**Consultation Response from KC,
Highways Development Management**

2024/93212 New Closes Farm, Wickins Lane, Holmfirth, HD9 3RB

**Alterations to convert existing store/workshop to one dwelling with associated parking,
outdoor amenity space and landscaping**

Date Responded: 06/02/2025

Existing Bock Plan

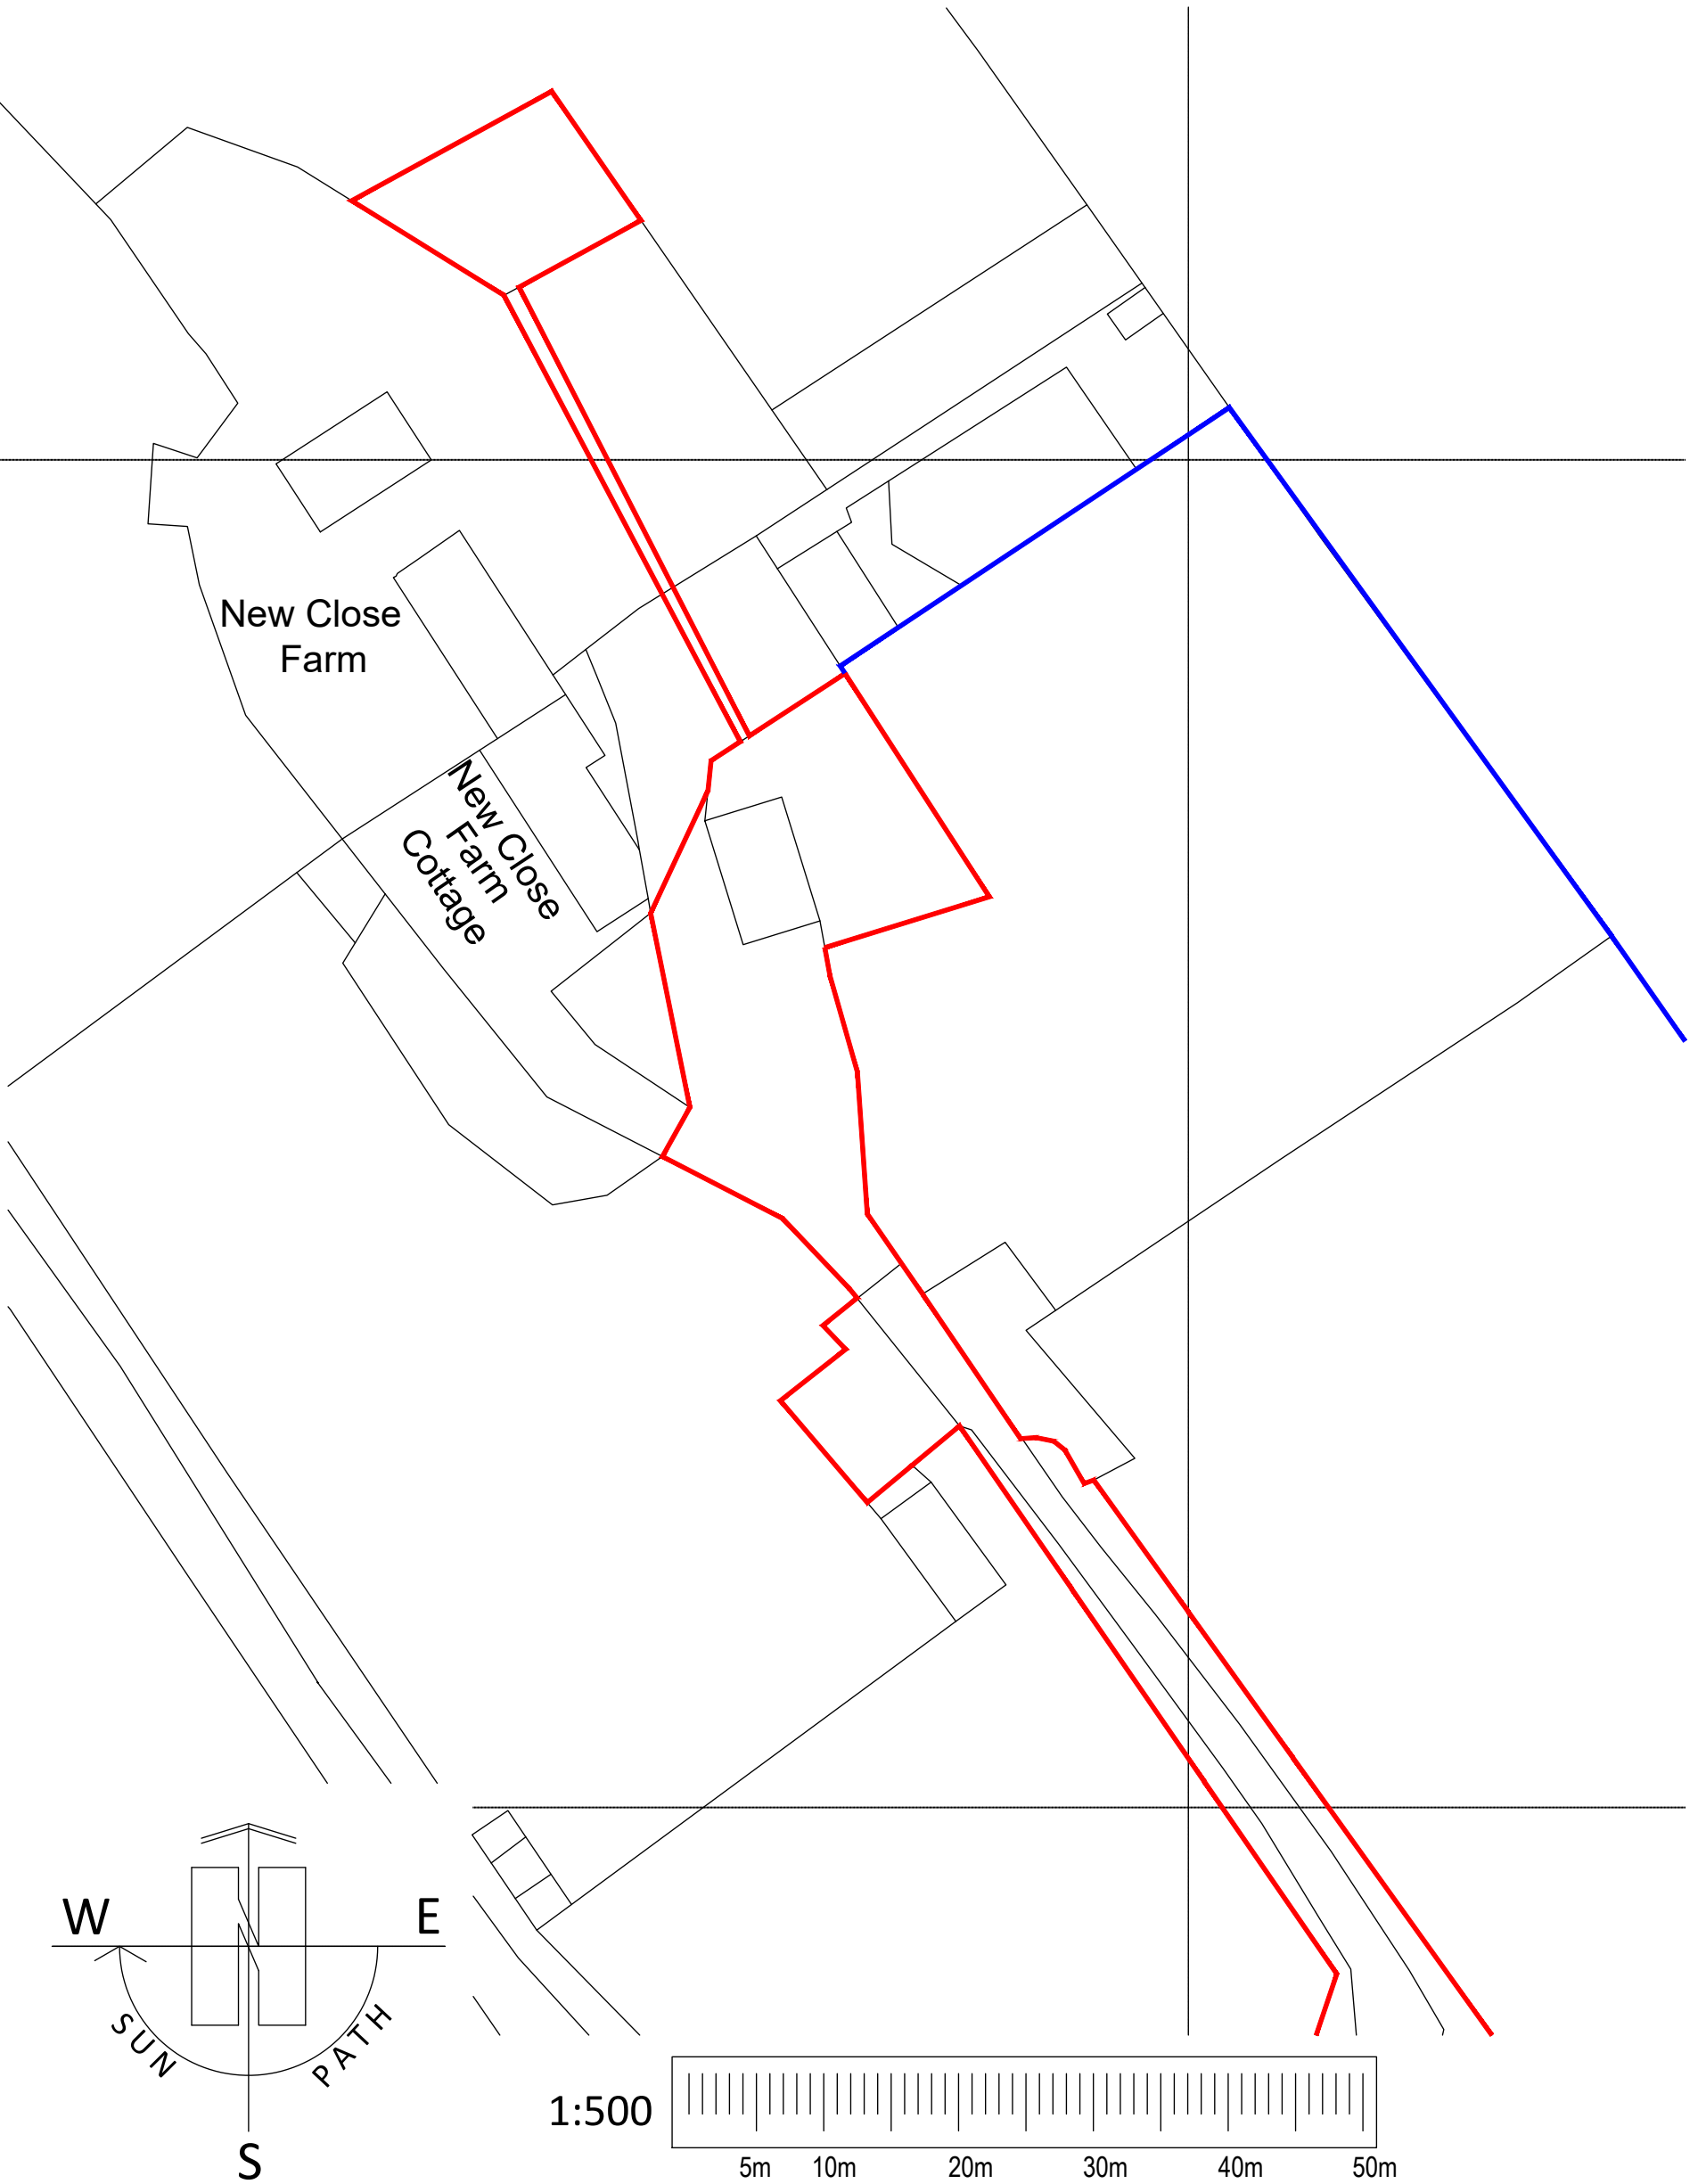
The width of the existing access track is substandard with a width of 2.9 with small grass verge at either side, however passing places have been provided at regular intervals and shown in the plans.

Parking is proposed for 2 vehicles which meets the guidance for a two bedroomed dwelling

The approved vehicle parking areas will need to be surfaced and drained in accordance with the Communities and Local Government; and Environment Agencies 'Guidance on the permeable surfacing of front gardens (parking areas)' published 13th May 2009 (ISBN 9781409804864) as amended or superseded.
